TOWN AND COUNTRY PLANNING ACT 1990 FULL

Reference:	H16-1111-22	Date of Decision:	5th January 2023
Applicant:	Mrs F T Mir Javadi 13a Fishpond Lane Holbeach Spalding PE12 7DE		
Location:	106 Halmer Gate Spalding		
Description:	Change of use from residential dwelling to HMO

J175-PL1A

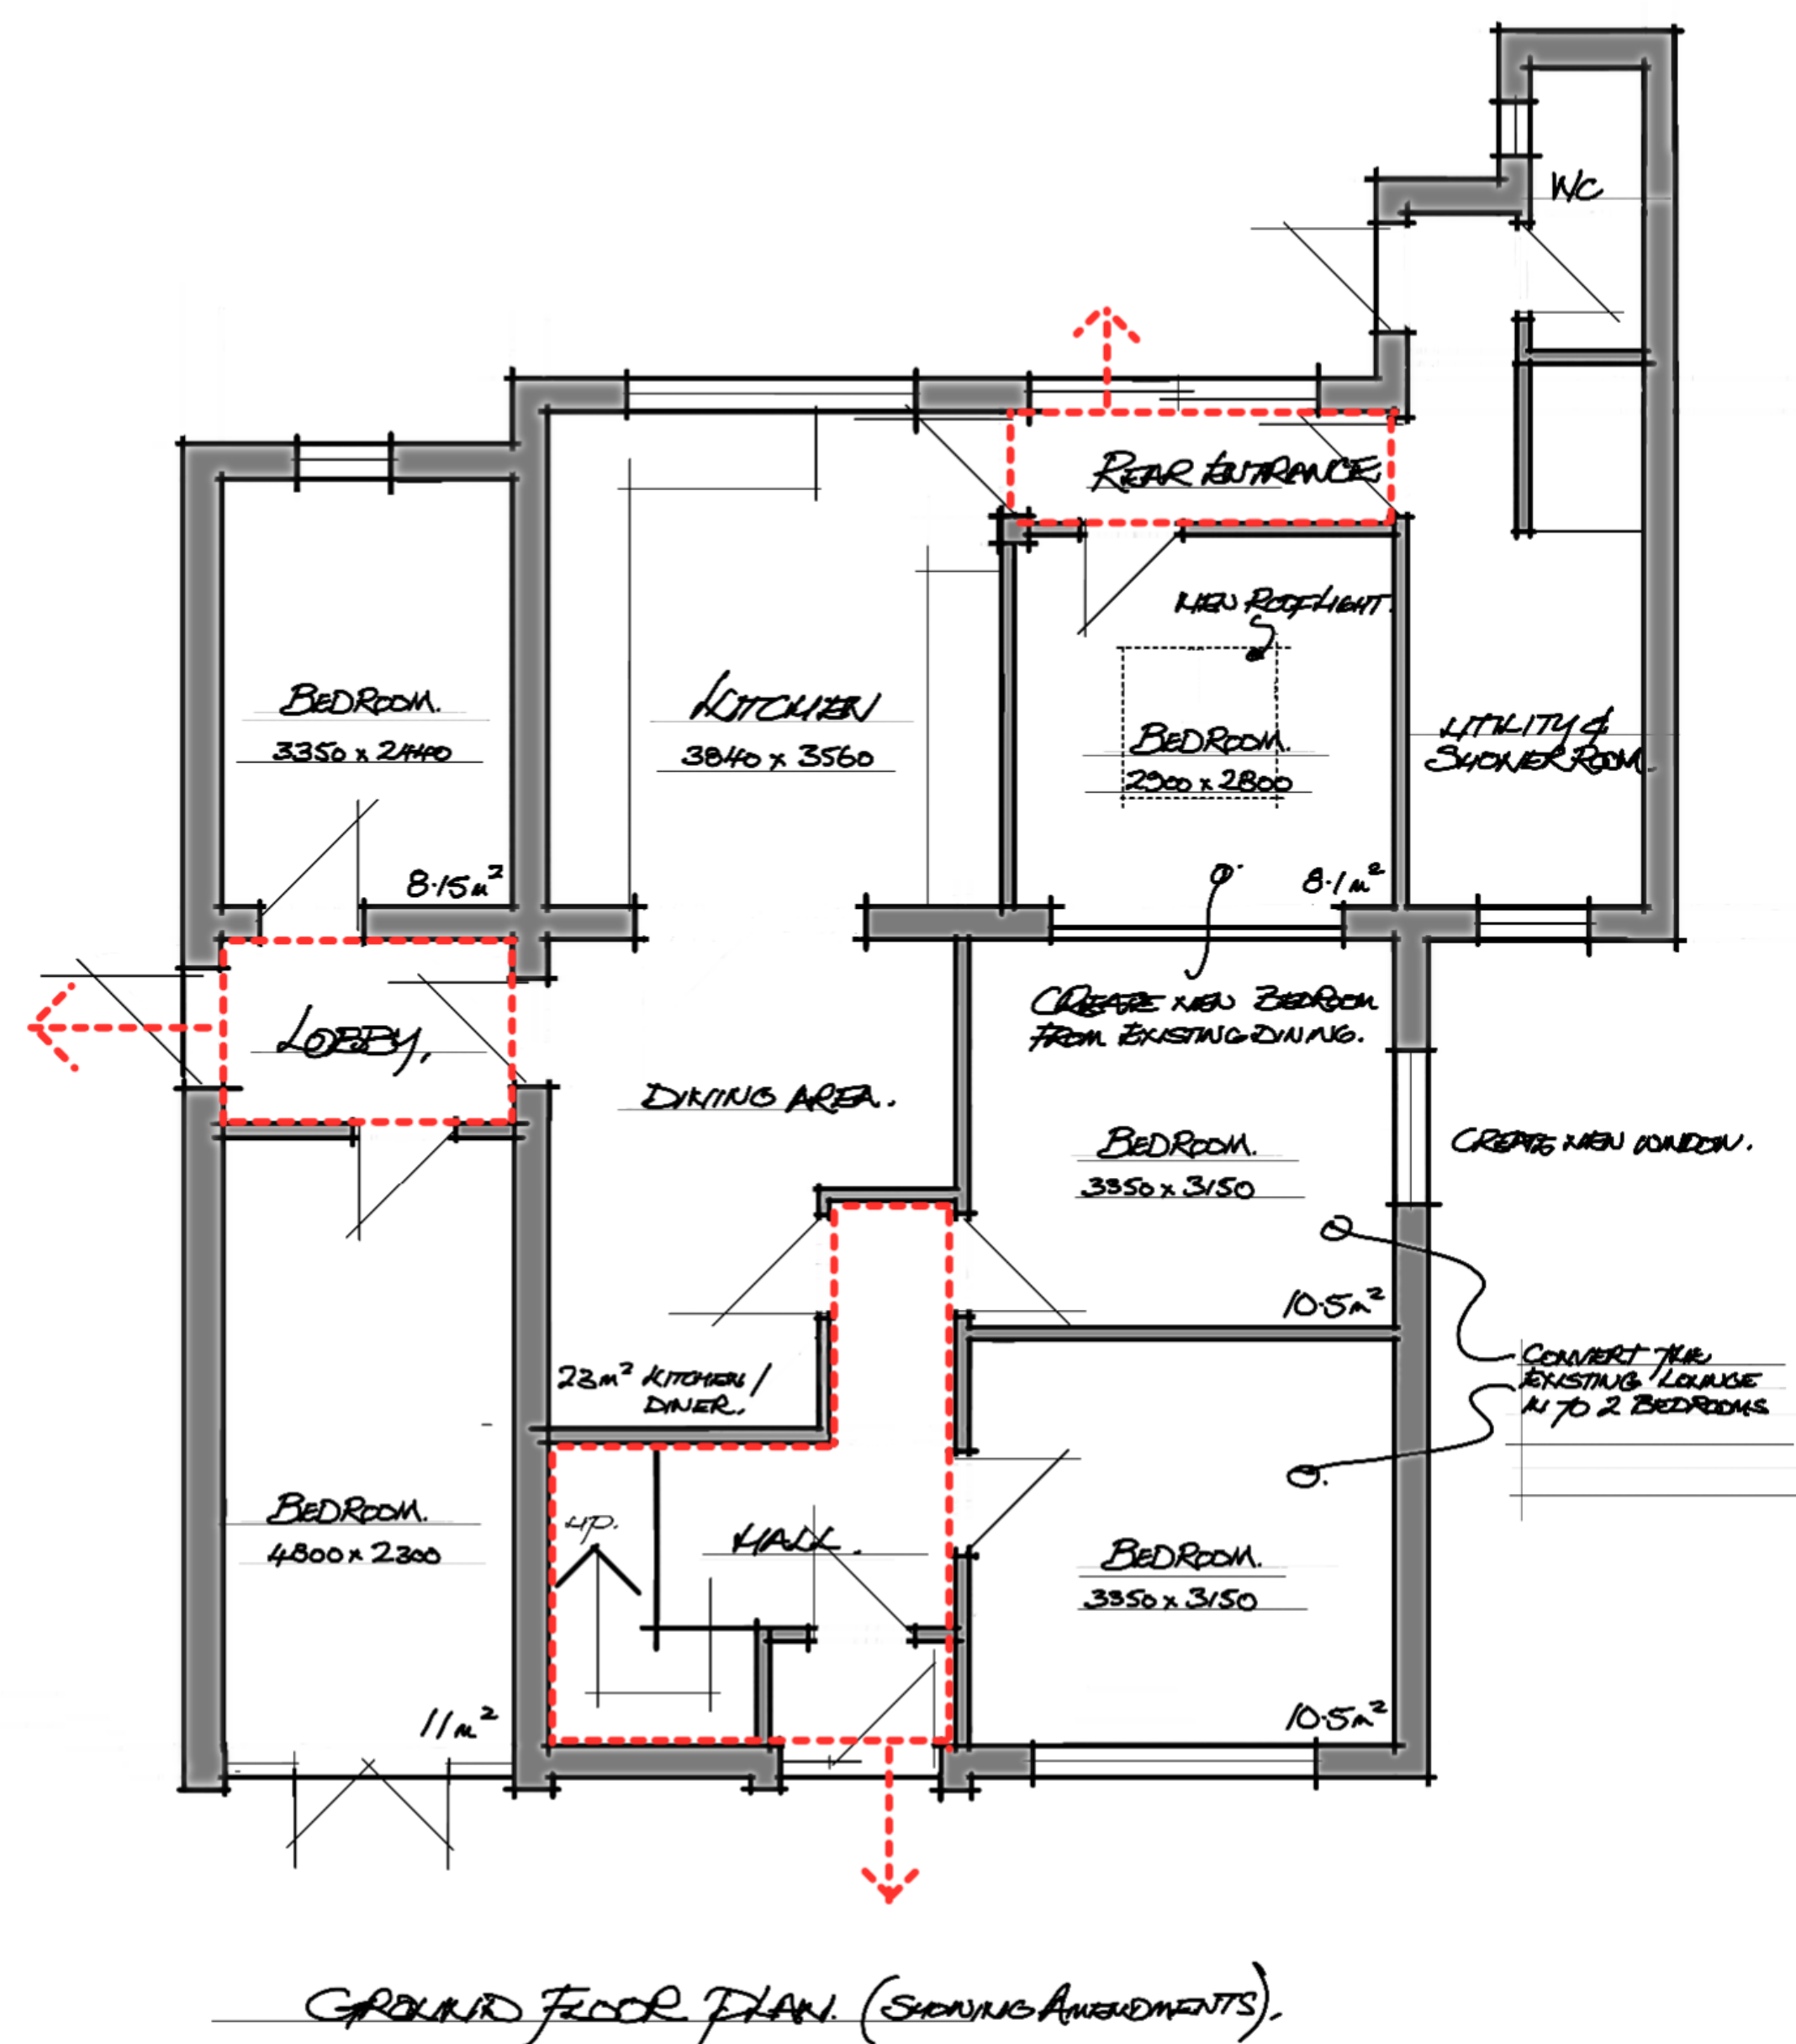
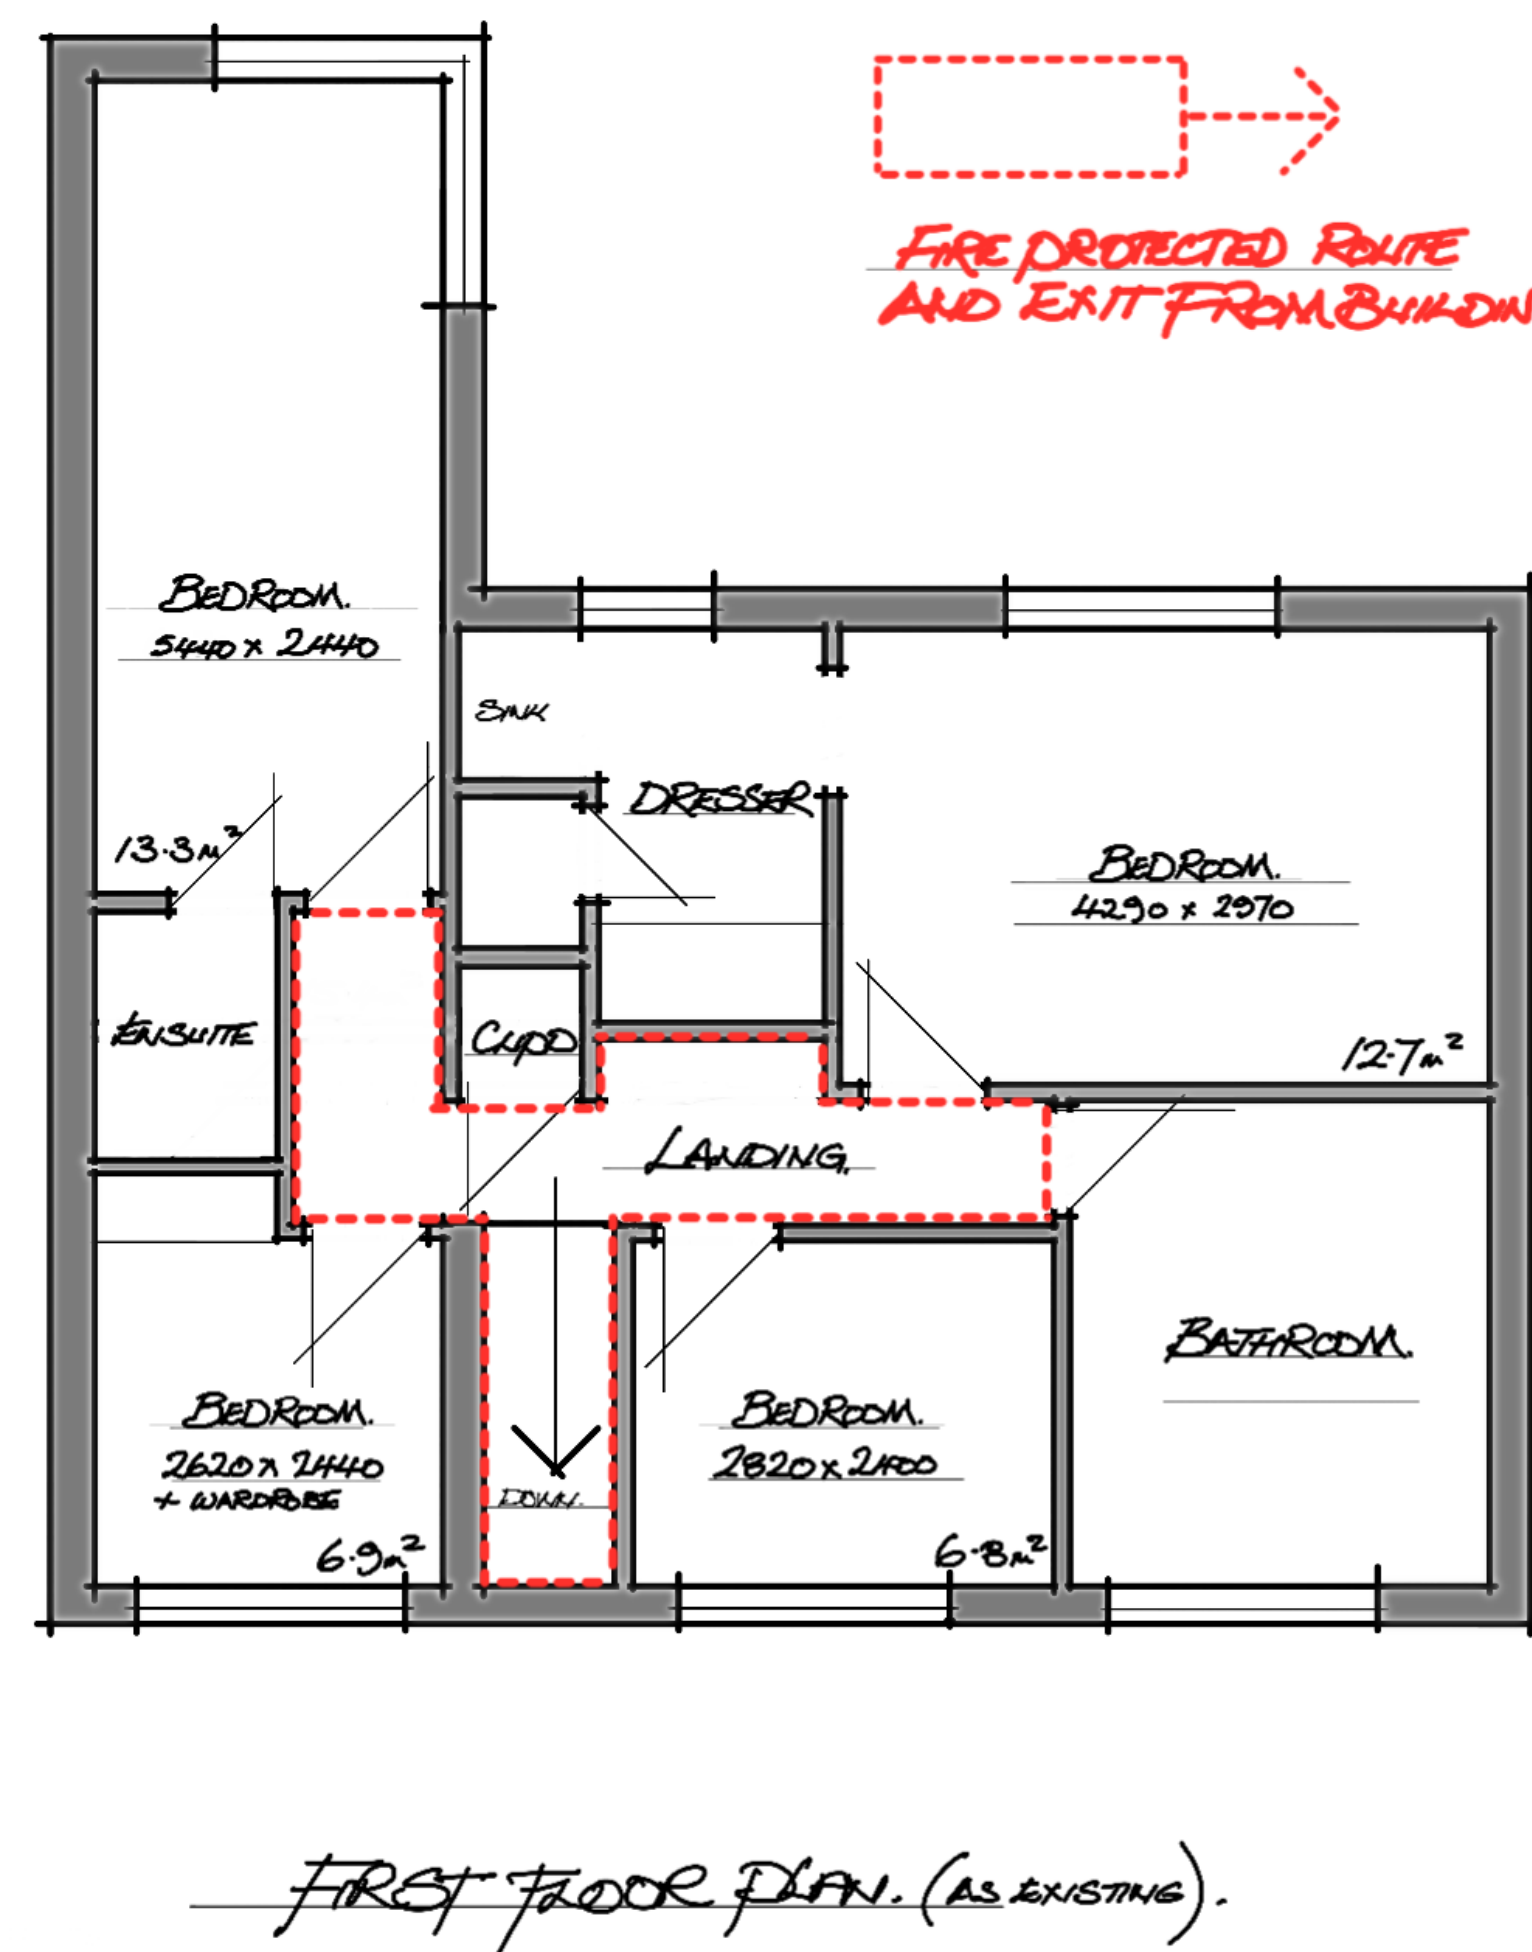
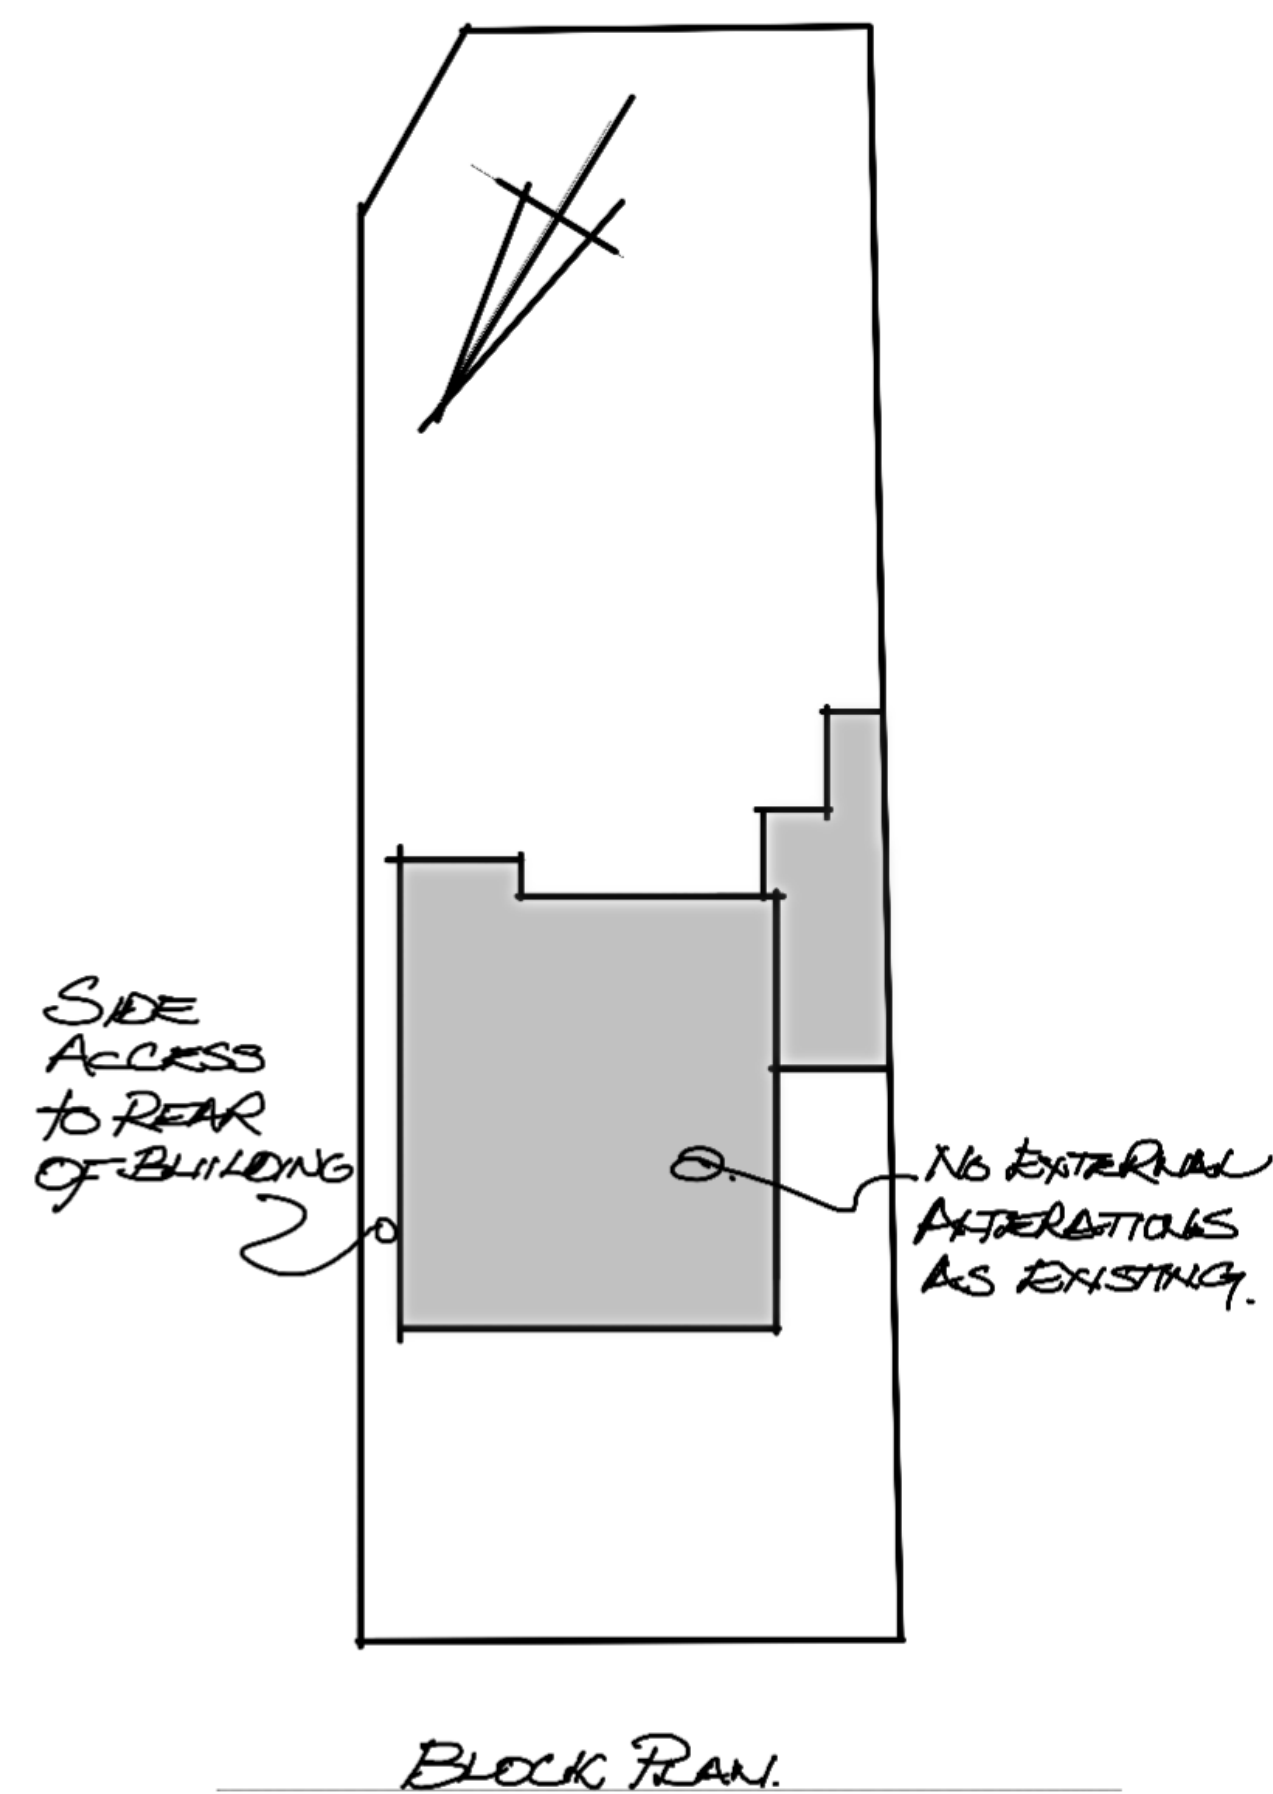
- 1 The property is considered to be of an inadequate size to accommodate what would likely be a minimum of 9 persons by virtue of small bedroom sizes (2 bedrooms on first floor) in the context of the Nationally Described Space Standards (2015) (NDSS), and only a single kitchen and dining space. This would represent an over intensification of the use of the property and may adversely impact the well-being of occupants or lead to outside gathering with a consequent amenity impact on neighbouring occupants. Overall, the noise and disturbance that would be generated would be uncharacteristic for an area of modest housing in single family occupancy.

- 2 Given that the HMO is intended to accommodate a minimum of 9 persons, there is the potential for a large number of vehicles to be associated with the property. The application

site is only capable of accommodating 3 off-street parking spaces for vehicles and the property only has a small road frontage. The proposal would likely result in the indiscriminate parking of vehicles on Halmer Gate and would impede traffic flow along a road that is particularly busy during school arriving and leaving times, thus being an inconvenient arrangement.
